From: Martyn White <Martyn.White@arun.gov.uk>
Sent: 18 February 2022 17:24
To: Planning.Responses <Planning.Responses@arun.gov.uk>
Subject: LU/411/21/PL

LU/411/21/PL

90-91 South Terrace Littlehampton BN17 5LJ

Change of use from existing leisure use to 10 No. 1-bedroom 1 person supported living apartments, staff office, staff sleepover and associated ancillary facilities to include extension to form new first floor. Alterations to roof space including creation of dormer windows & installation of roof lights. This application is in CIL Zone 4 (zero rated) as flats.

project	Proposed Development 90-91 South Terrace Littlehampton, W Sussex
detail	Proposed Elevations
drawn	MAS
date	Dec 2021
at scale	a3 scale
1:100	1:200
status	Planning
rev	28118-PD210

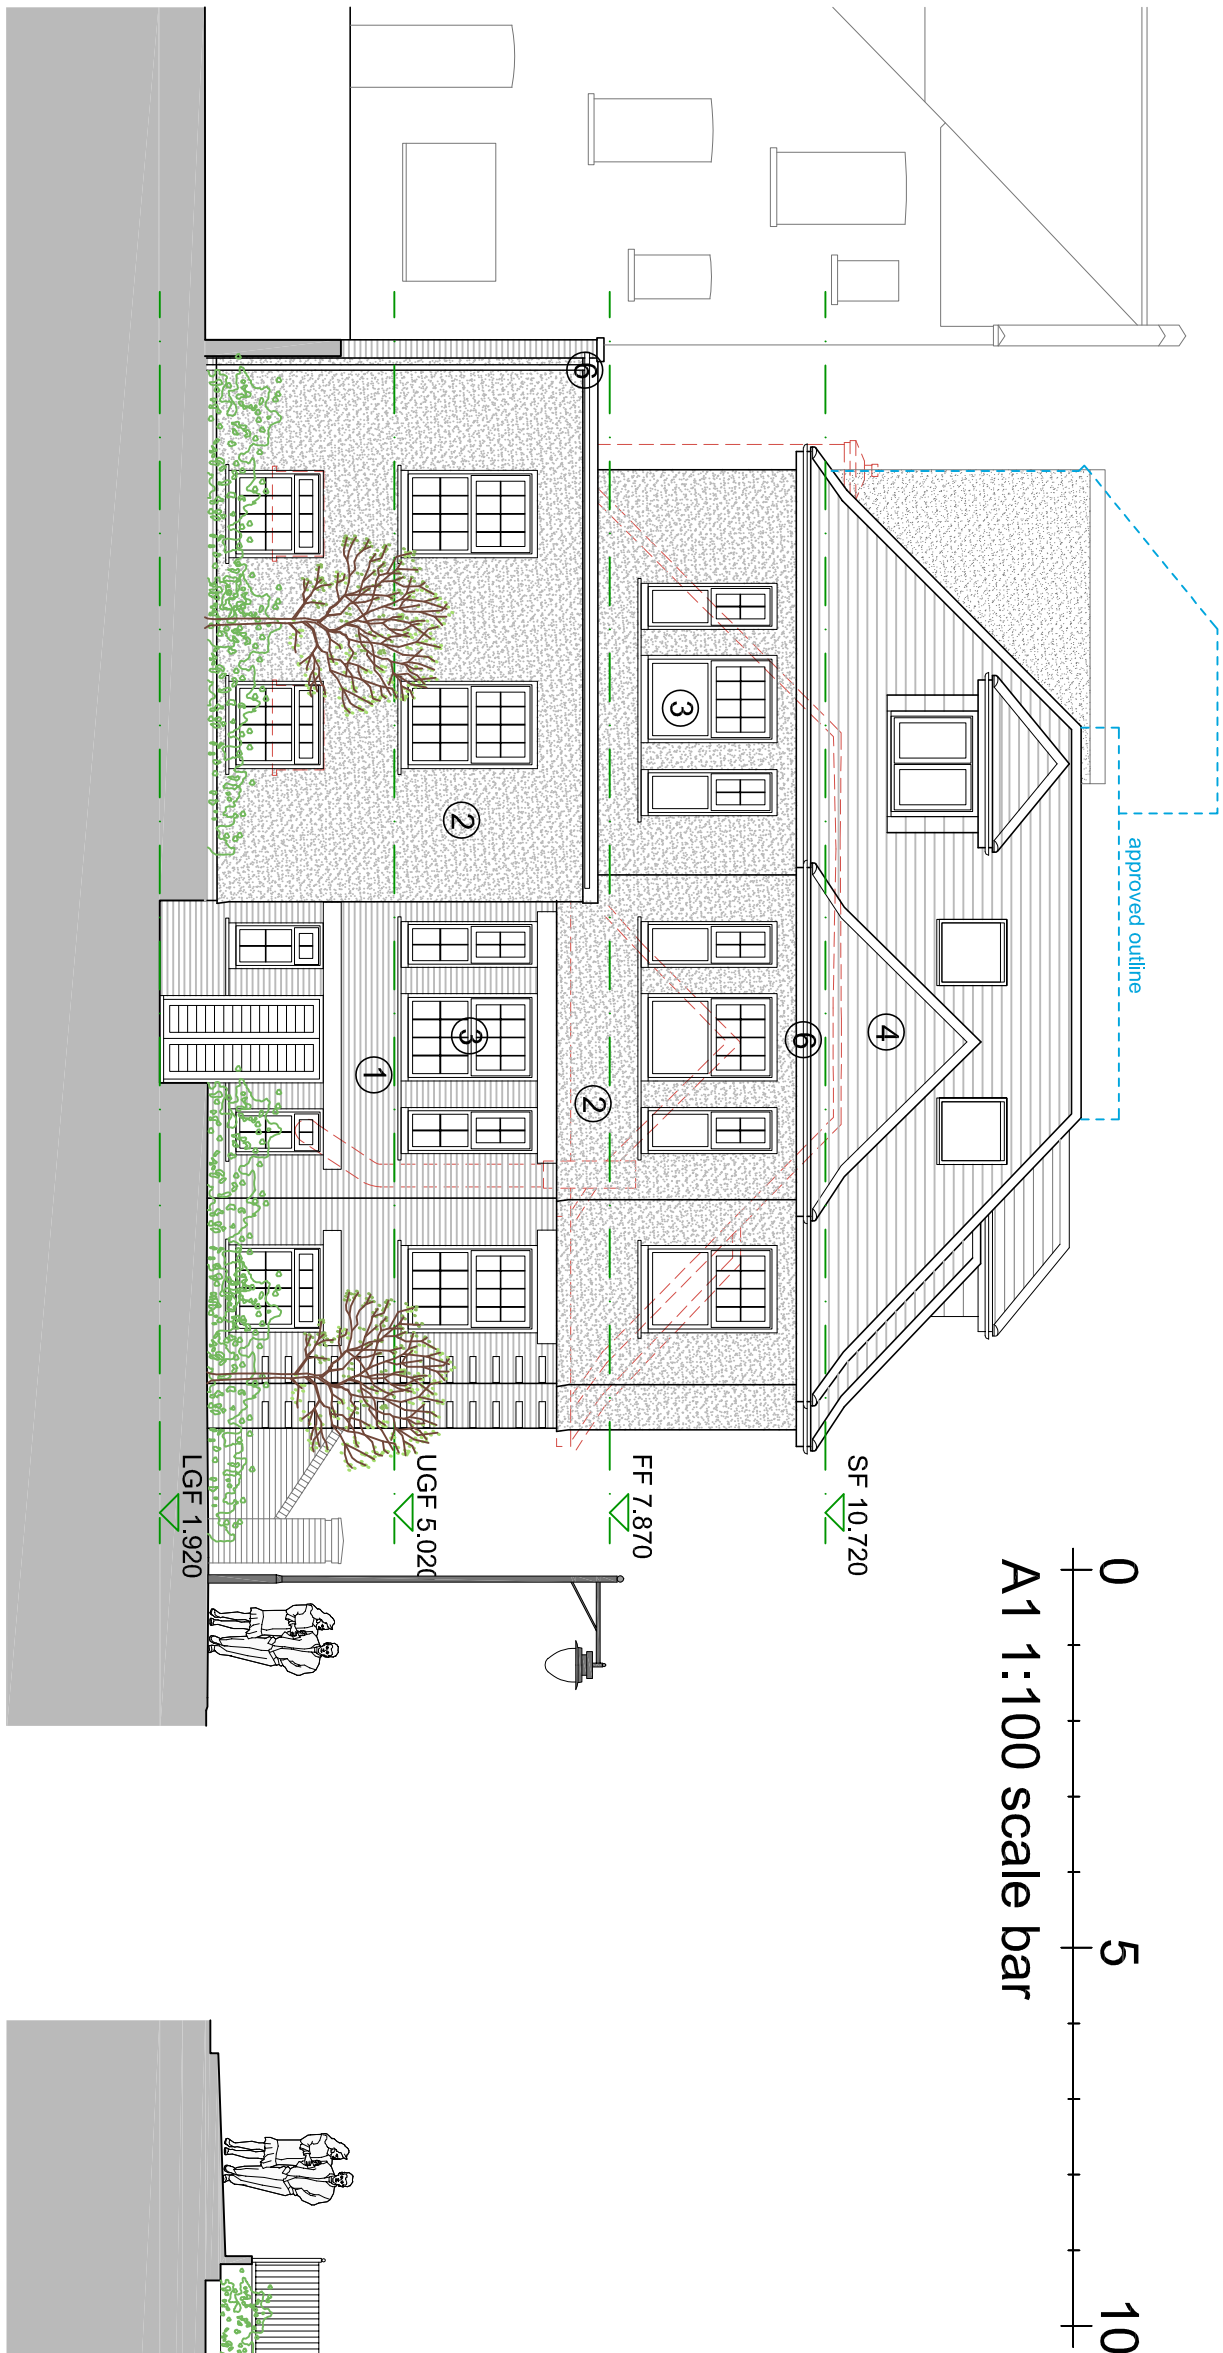
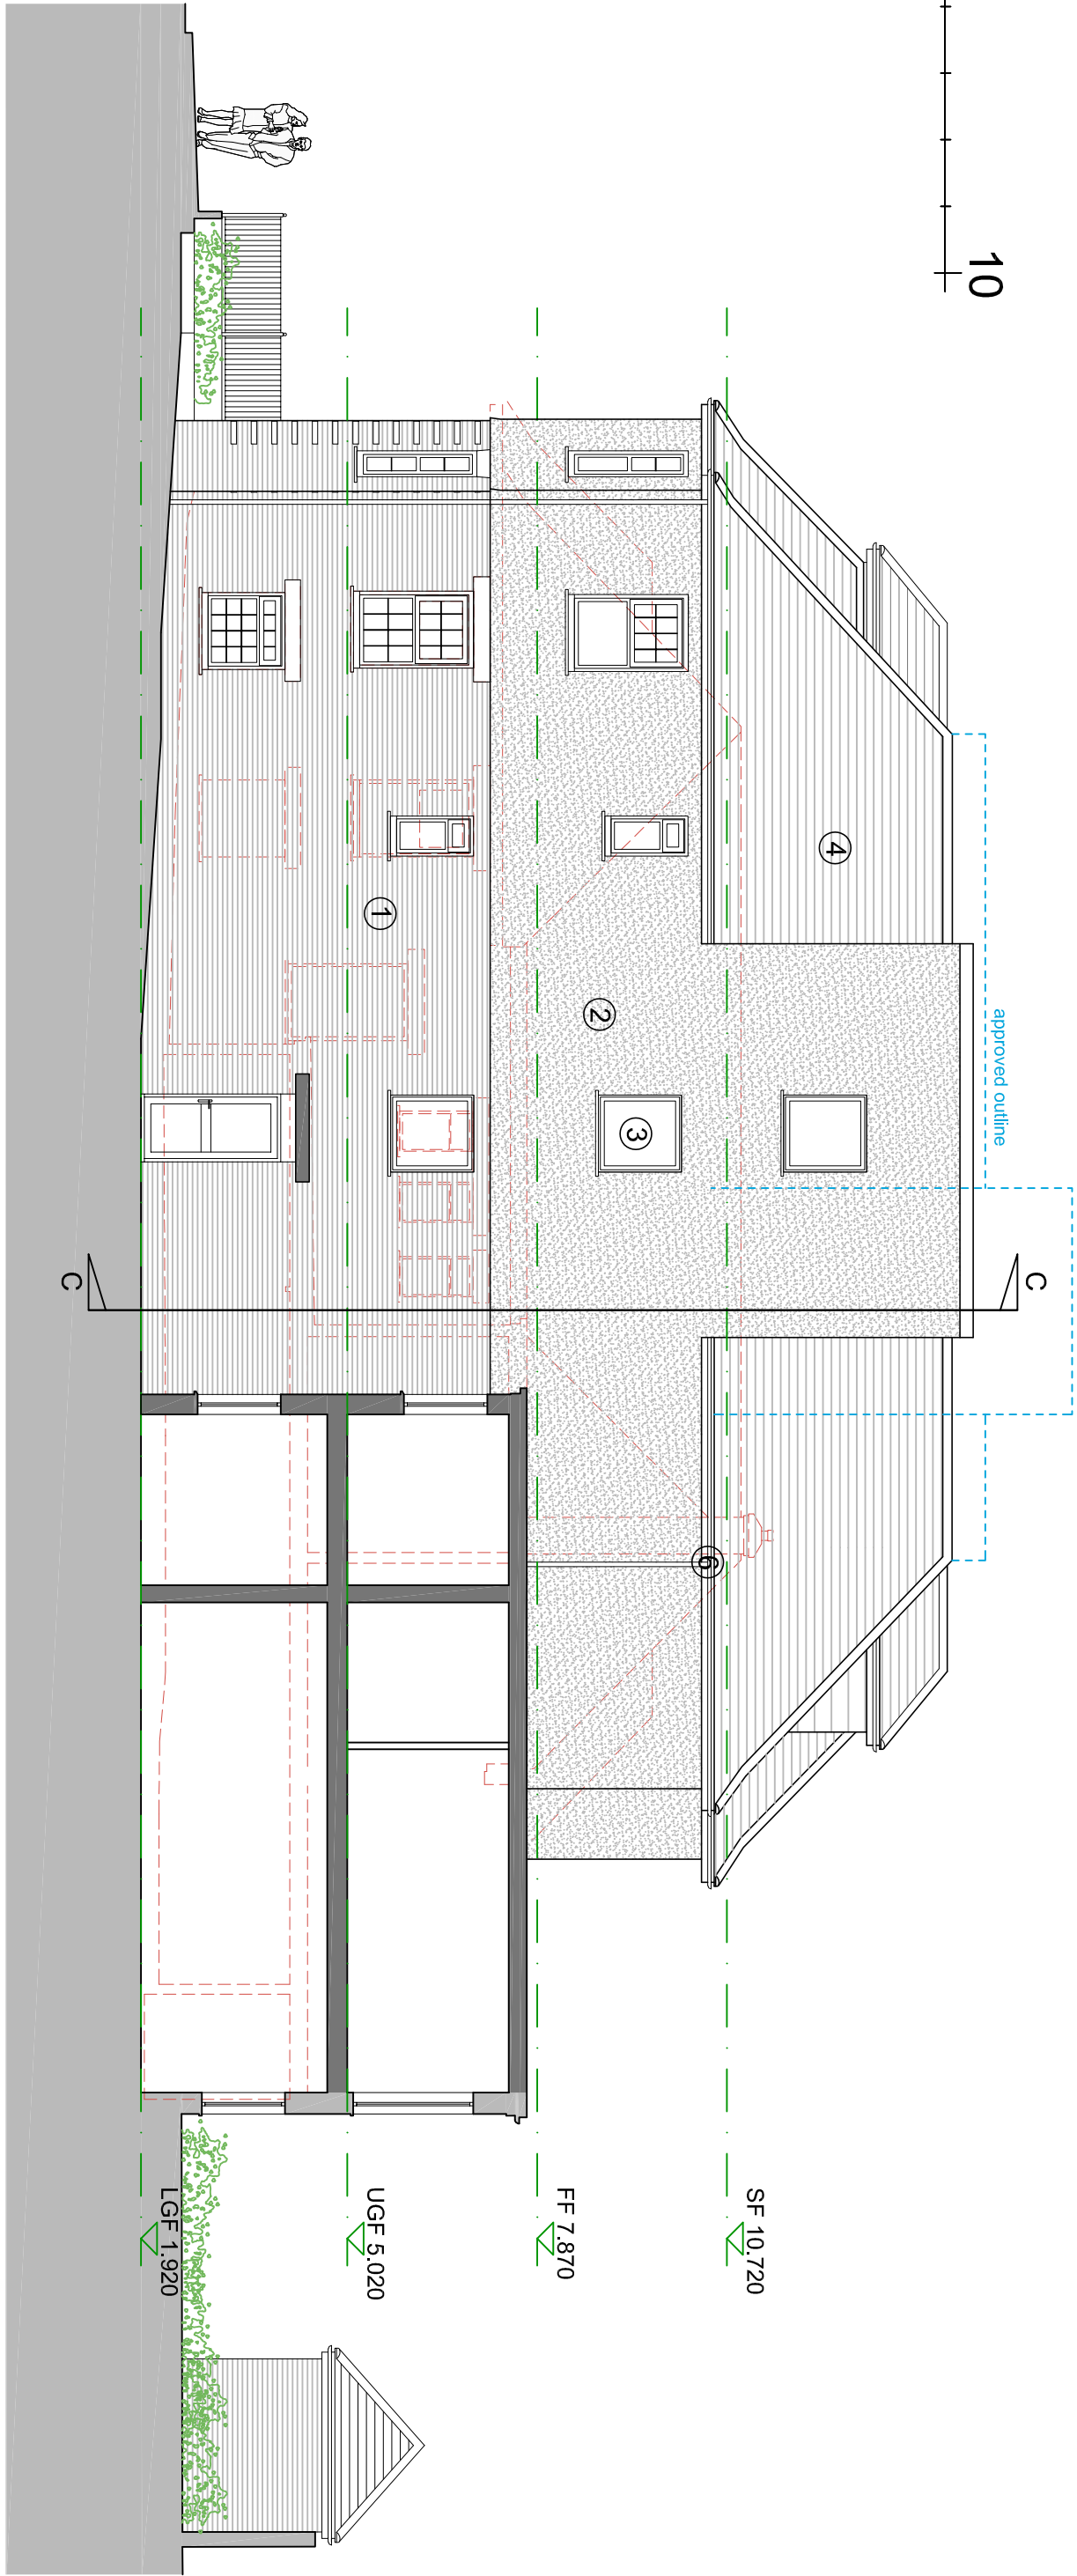
However, I note that in this application the intention is not to face the elevations of the additional floors in matching brick as previously approved. Instead, the intention is to face the new build upper storeys in sand coloured render. The Design and Access statement identifies that there are a couple of reasons for this, the first being that it would not be possible to match the new brick with the existing ones, which will have weathered over time. I note that the intention with this approach is that it will clearly 'define the new against the old which in time will weather accordingly'. Whilst as noted, there are examples of upper storey render in a sand colour on the adjacent terraces, the areas present on the front elevations are minimal. It is also not clear if the render would be rough textured (as used elsewhere) or smooth. The proposal could potentially look very out of character with the two neighbouring terraces. Further, it is clear that the attractive quoining present on the building will also be missing, which is disappointing as it would mean that the additional floor would look out of character.

Likewise, it is not clear why a graphite grey slate roof with terracotta hips and ridges is proposed, when the majority of the roofs visible along the terrace are clearly clay tiled. The design and access statement itself acknowledges this in part when it says "Whilst the area does have predominantly clay tiled roofs, there are slate roofs in the area and such a treatment is not to the detriment of the design or the wider character of the area which has an eclectic mix of styles and materials within its locality". I would disagree with this suggested approach, especially when such a large roof would be clearly visible in the context of the terrace, and out of place in an area where the roofs of the terrace are clearly fully clay tiled.

Therefore, whilst this proposal is acceptable in terms of massing and appearance, being similar to the previously approved plan, there are some strong concerns regarding the proposed appearance as a result of the proposed materials, consequently the application cannot be supported and is considered to be harmful.

It is considered that the external treatment of the proposed development will have a negative impact upon the building, will be out of keeping with those in the Area of character and would be harmful. As a consequence, the application should be determined in accordance with the relevant policies within the Development Plan, the NPPF, along with these comments.
